Planning Application Ref: F/4/20/OUT

Location: Land at Ford Airfield, Ford

Description of works: Outline planning application (with all matters reserved except for access) for the development of up to 1,500 dwellings (Use Class C3), 60-bed care home (Use Class C2), up to 9,000 sqm of employment floorspace (Use Classes B1), local centre of up to 2,350 sqm including up to 900 sqm retail / commercial (Use Classes A1-A5) and 1,450 sqm community / leisure floorspace (Use Classes D1-D2), land for a two-form entry primary school (Use Class D1), public open space, allotments, new sports pitches and associated facilities, drainage, parking and associated access, infrastructure, landscape, ancillary and site preparation works, including demolition of existing buildings and part removal of existing runway hardstanding. This application affects a Public Right of Way. This application is the subject of an Environmental Statement. This application may affect the setting of a Listed Building. This application falls within CIL Zone 1 - Zero Rated

Mark Warwick
Tree Officer / Parks and Greenspace Team

T:\Projects\13000 Series\130911TB Ford Airfield\Transport Drawings\Working Drawings\GA\ITB13091-GA-004 Rev A.dwg

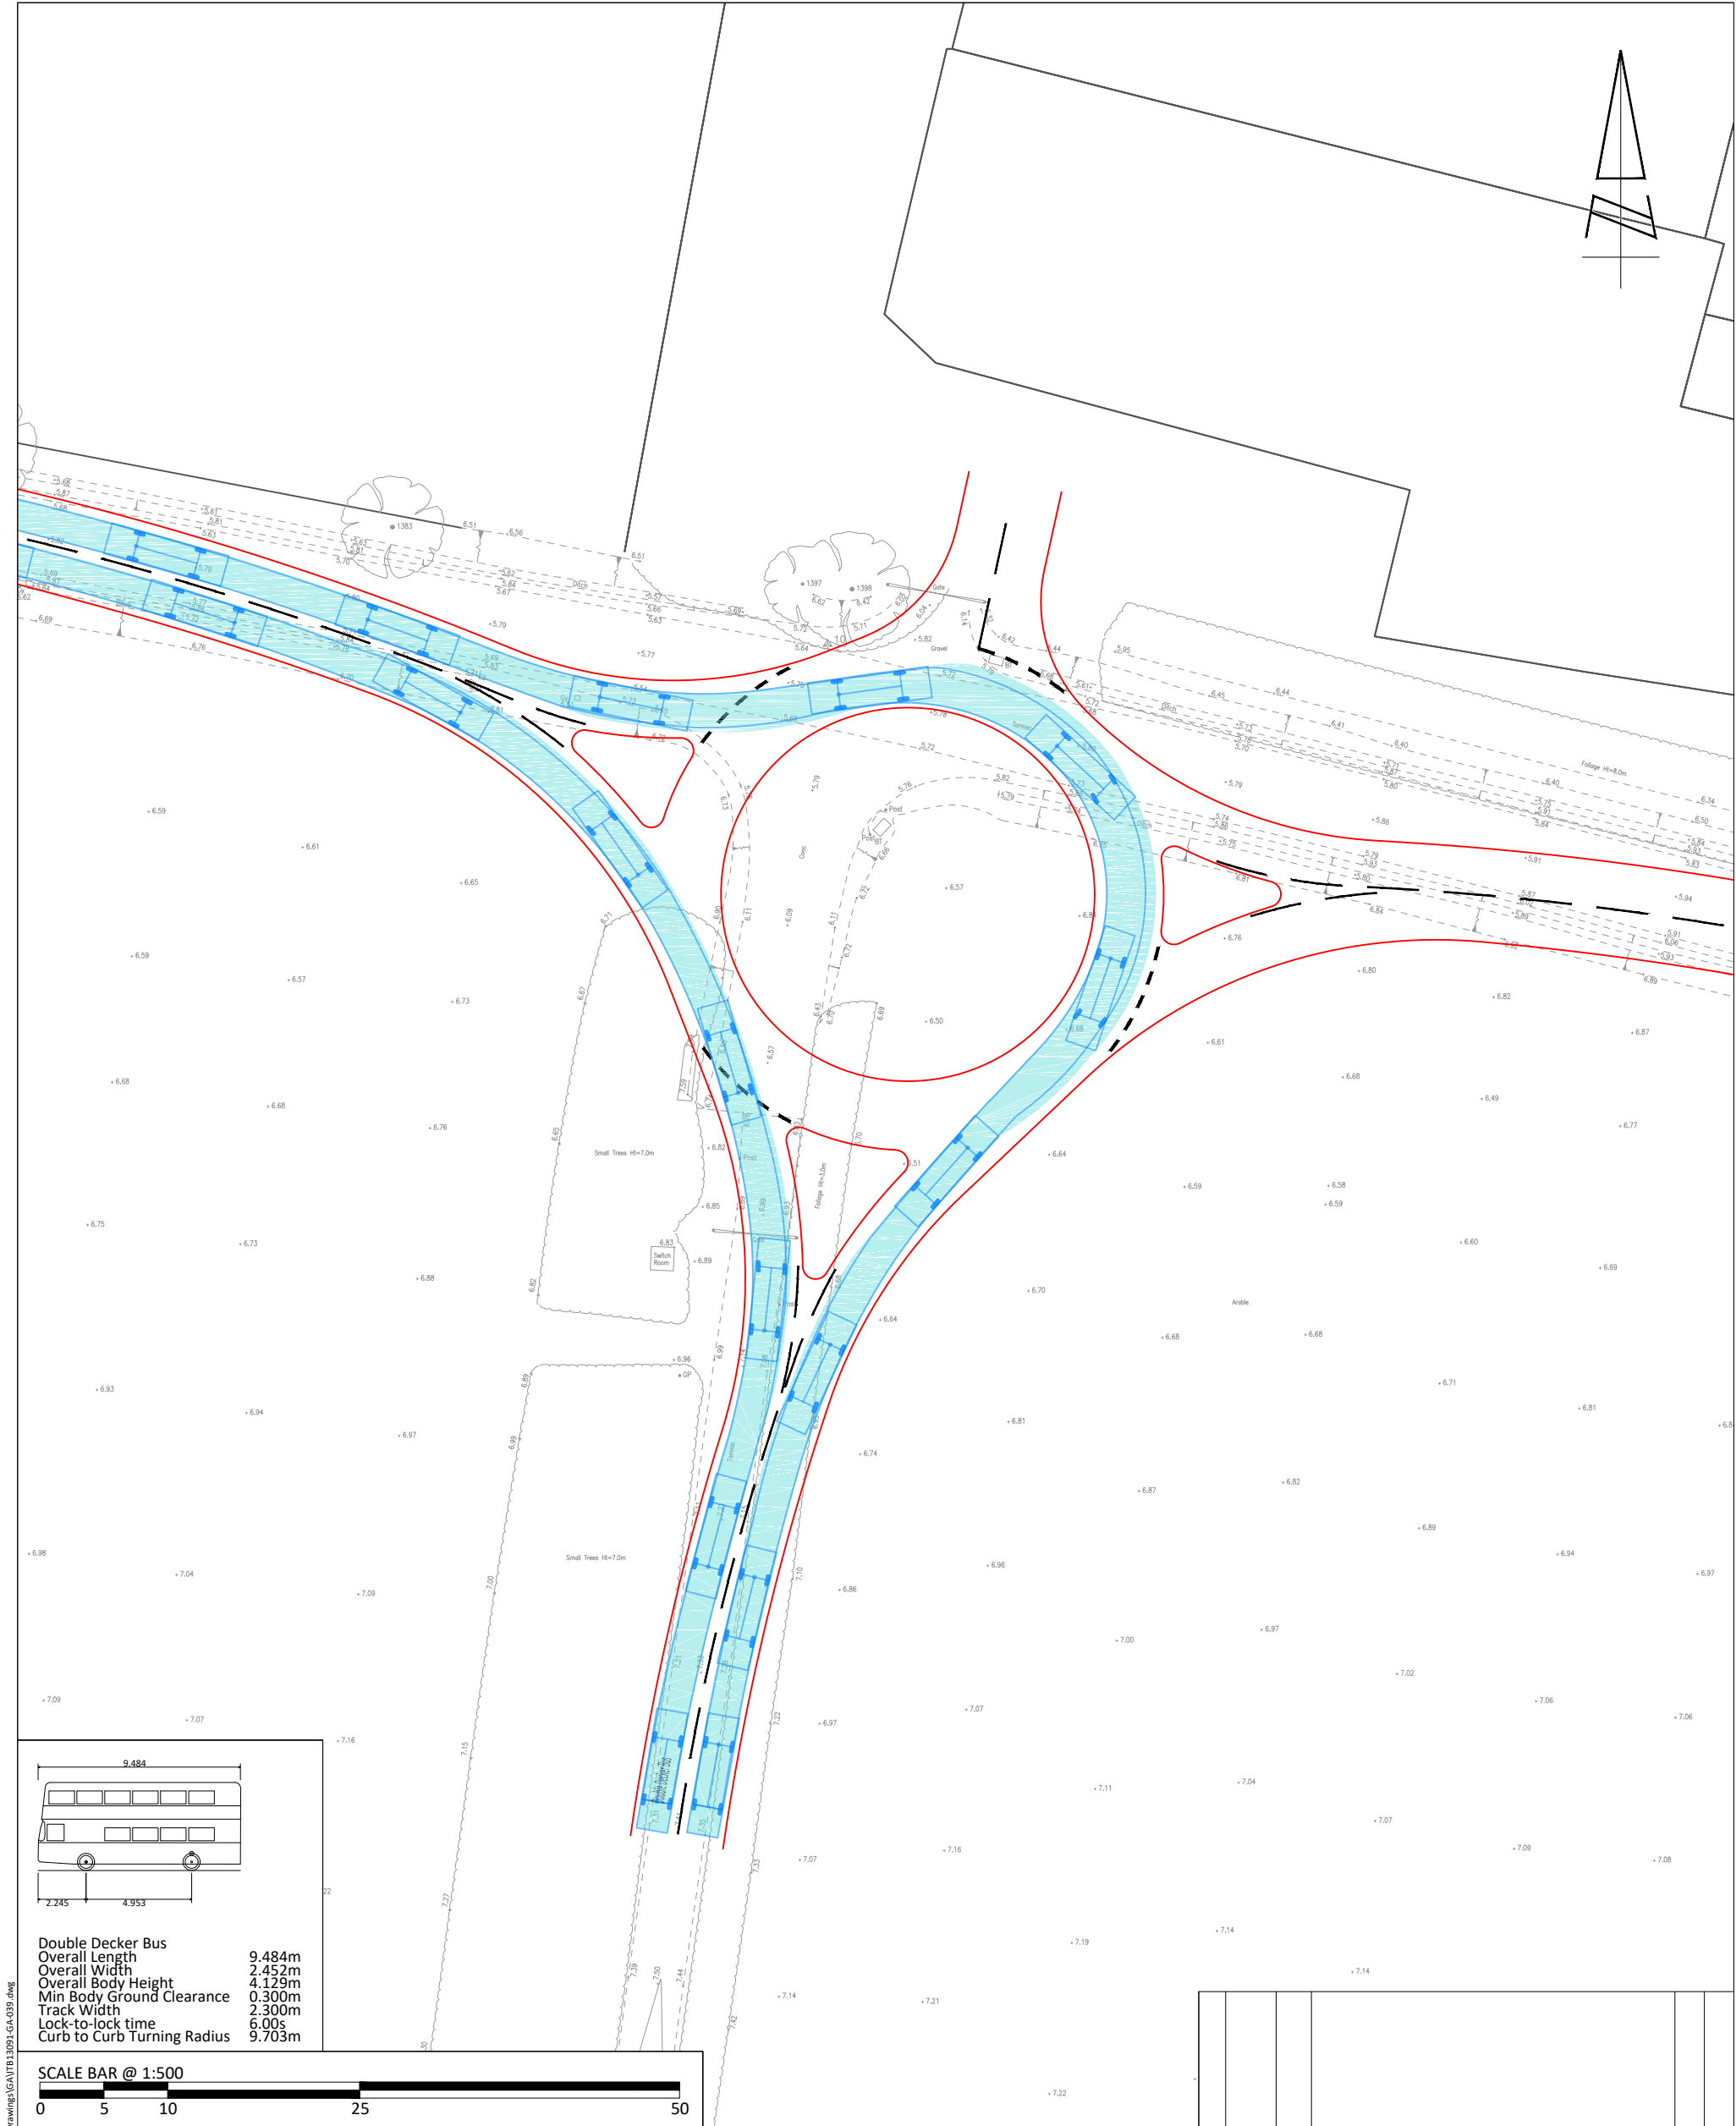
- III) **Potential Site Access Arrangement – 3 Arm 40m ICD Roundabout** (dwg. ITB13091-GA-004, Rev A). *This is for entry to/from Ford Lane. No obvious conflict with existing trees alongside existing/potential infrastructure and within sightlines.*

REV	DATE	BY	DESCRIPTION	CHK	APD
STATUS: FOR INFORMATION					
SCALE @ A3: 1:500		CHECKED: DS		APPROVED: DS	
FILE REF: ITB13091		DRAWN: JD		DATE: 26.11.18	
DRAWING No: ITB13091-GA-021					
PROJECT No: ITB13091				REV: -

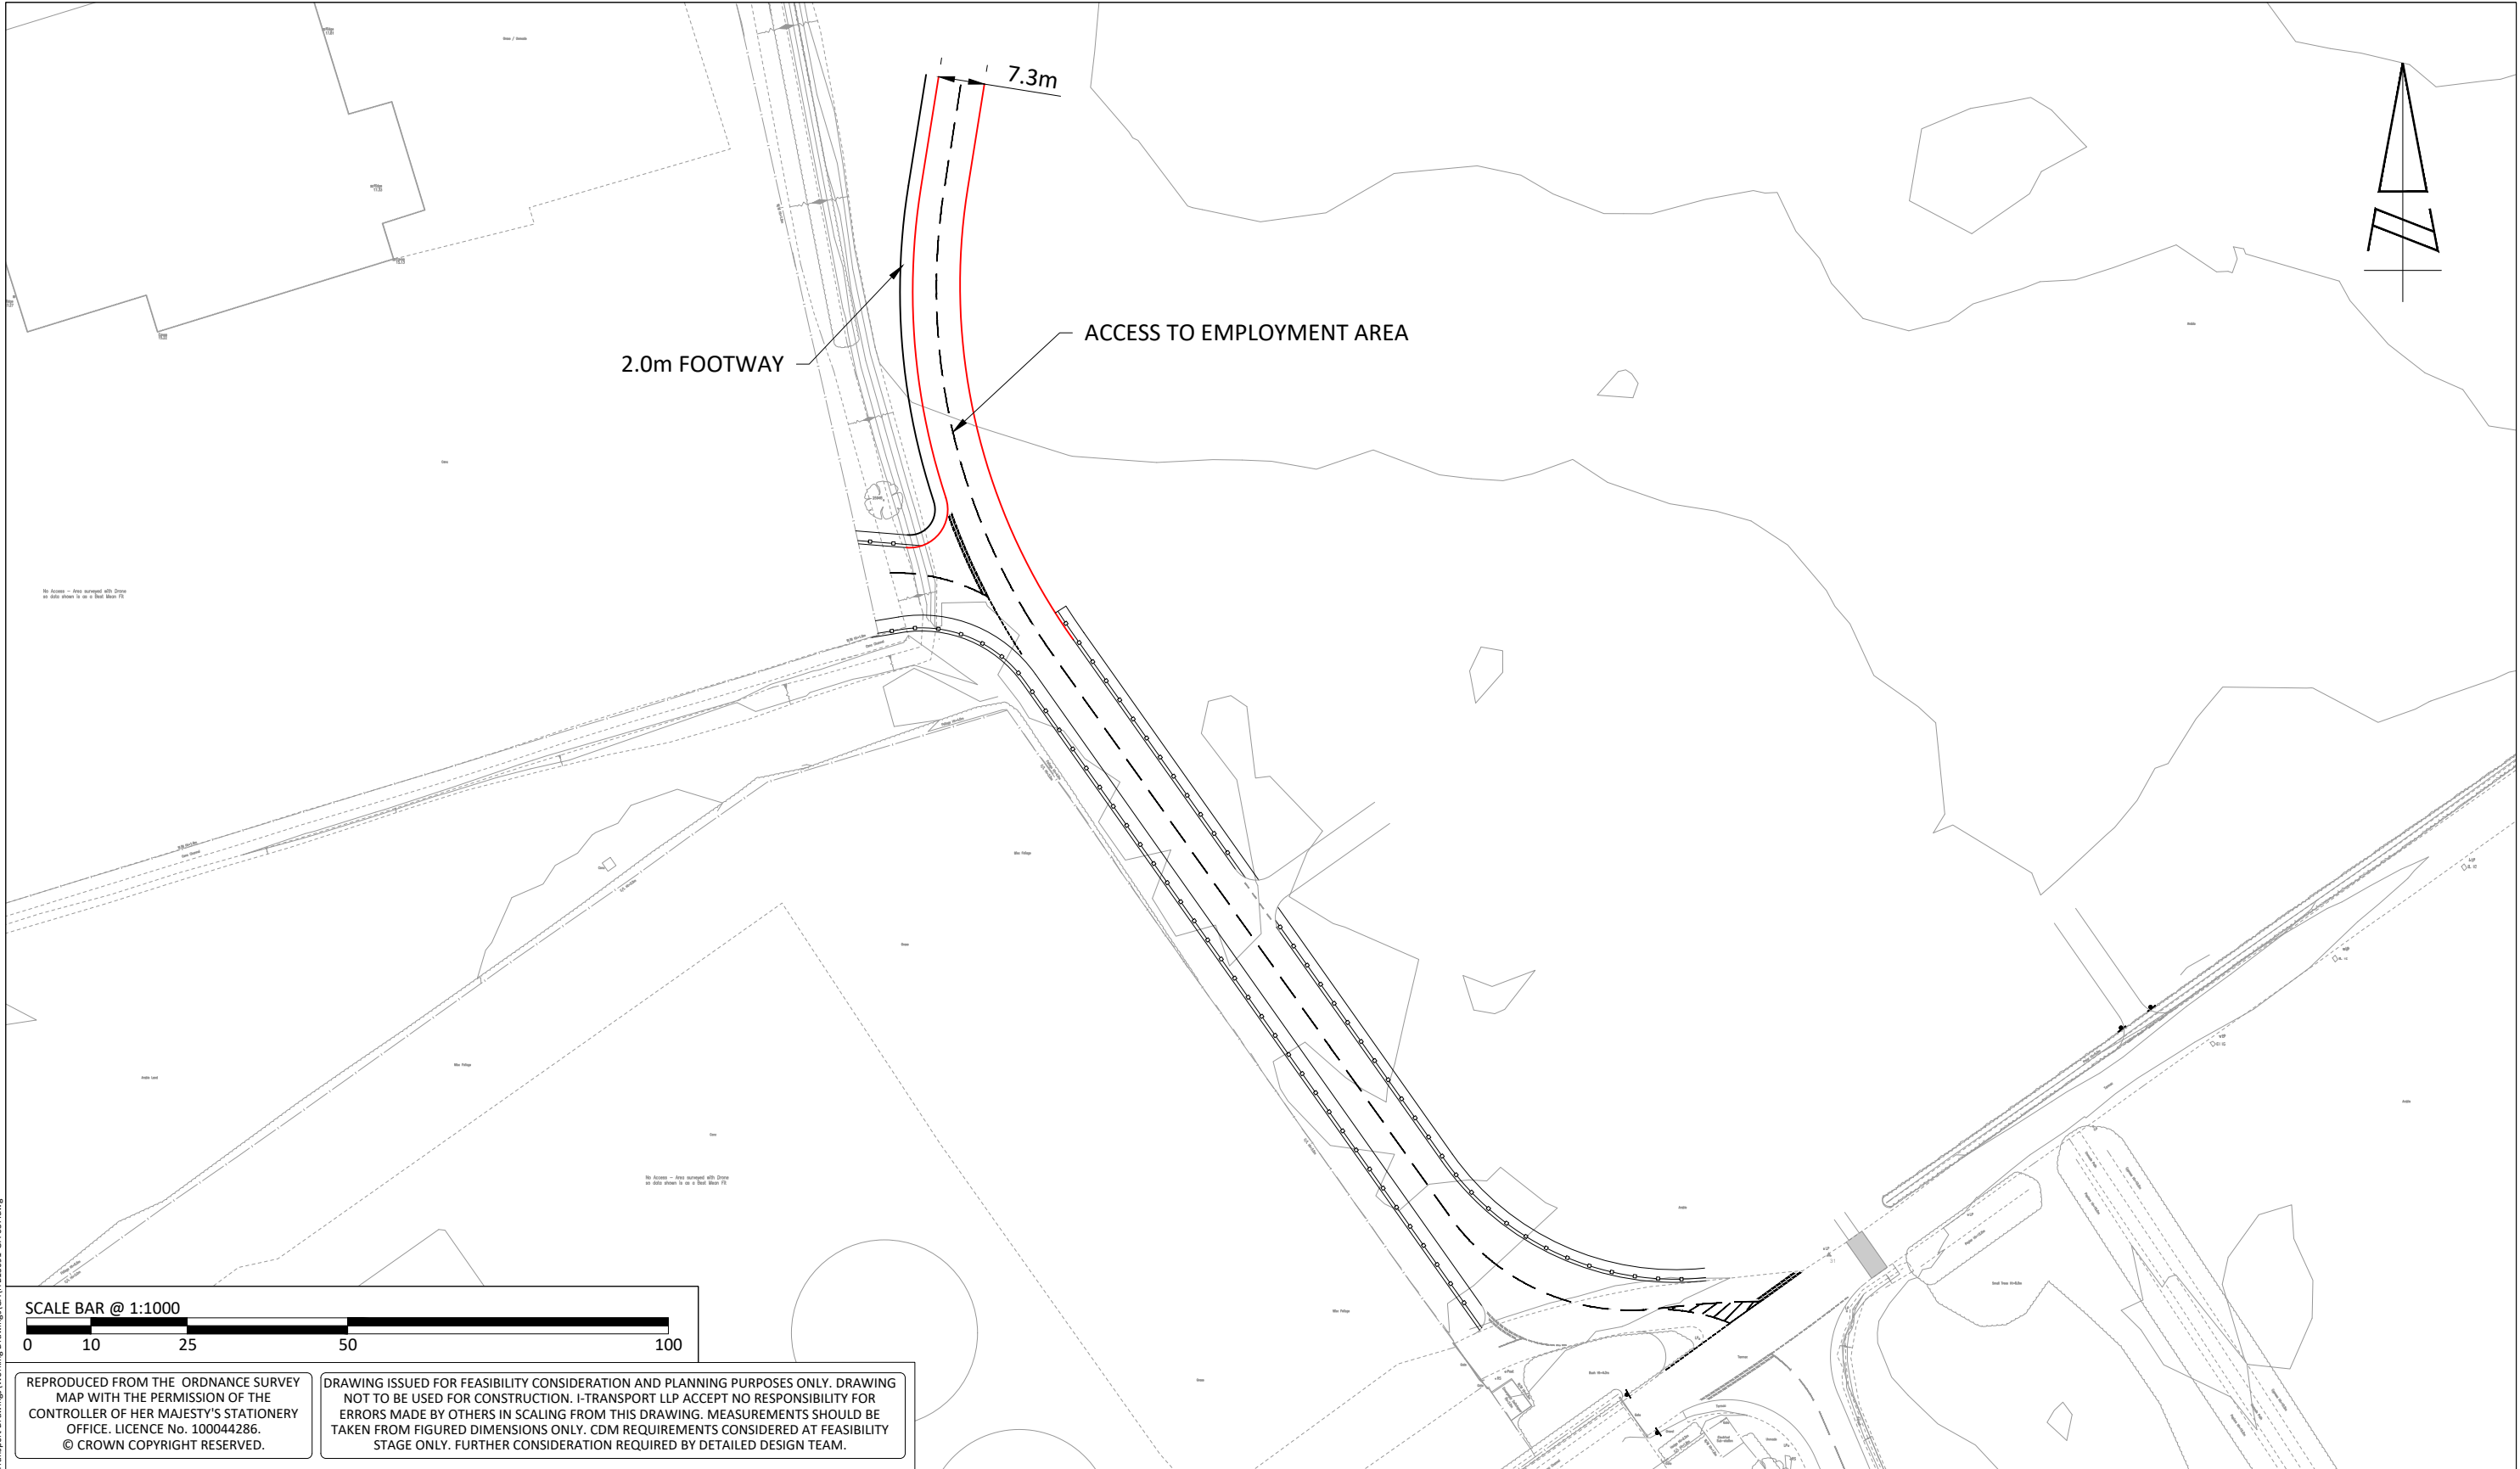
- **Main vehicular access routes are proposed at three locations. I have considered the following plans:**
 - I) **Ford Airfield Geometry, Eastern Access Onto Ford Road** (dwg. ITB13091-GA-021, Rev-)
No obvious conflict with existing trees alongside existing infrastructure and within sightlines. Any subsequent footway provision should be restricted to South side of the road only, away from valuable hedgerow and trees.

FIGURE 5. ILLUSTRATIVE MASTERPLAN

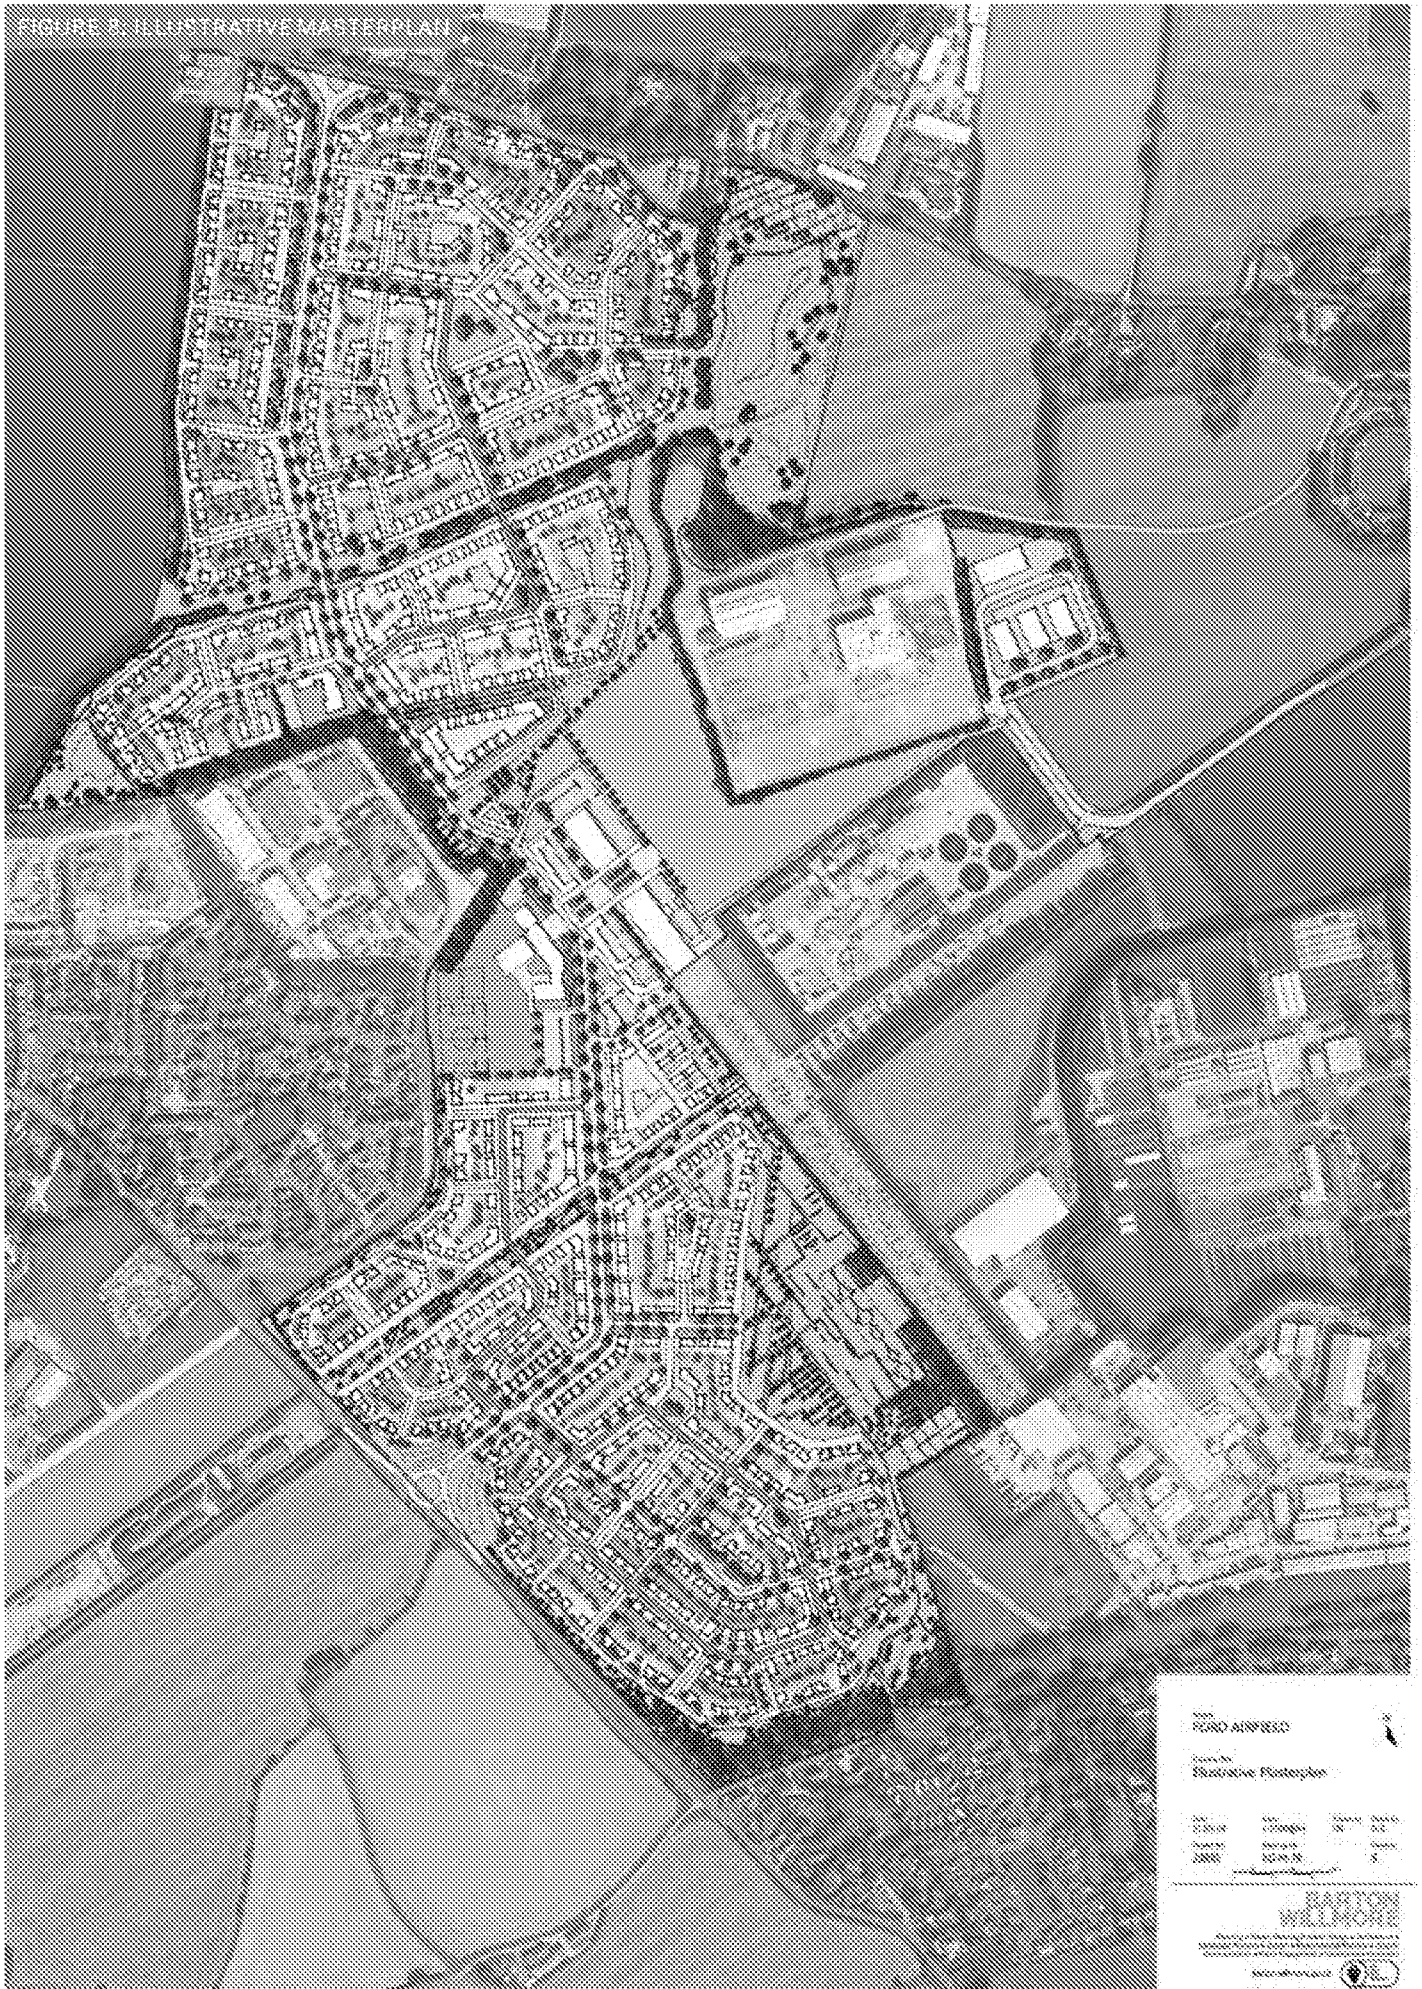
- I find the **parameter plans and Illustrative Masterplan RG-M-78, Rev W** broadly supportable. As design layout evolves and becomes more detailed, it will be important to consider the following:

- Sites of this size and generally open nature but with established landscape features (trees and hedgerow), should be subject to the higher-level development principles, as promoted in our Supplementary Planning Documents. Those give instruction for avoiding Root Protection Area (RPA) incursion and providing further insurance with the use of 2metre buffer zones. **Arun District Public Open Space, Playing Pitches and Built Facilities** (Appendix 9) and **Arun Design Guide** (E.02 Landscape Structures & Trees, p48) - [Supplementary Planning Documents \(SPDs\) and other guidance | Arun District Council](#).
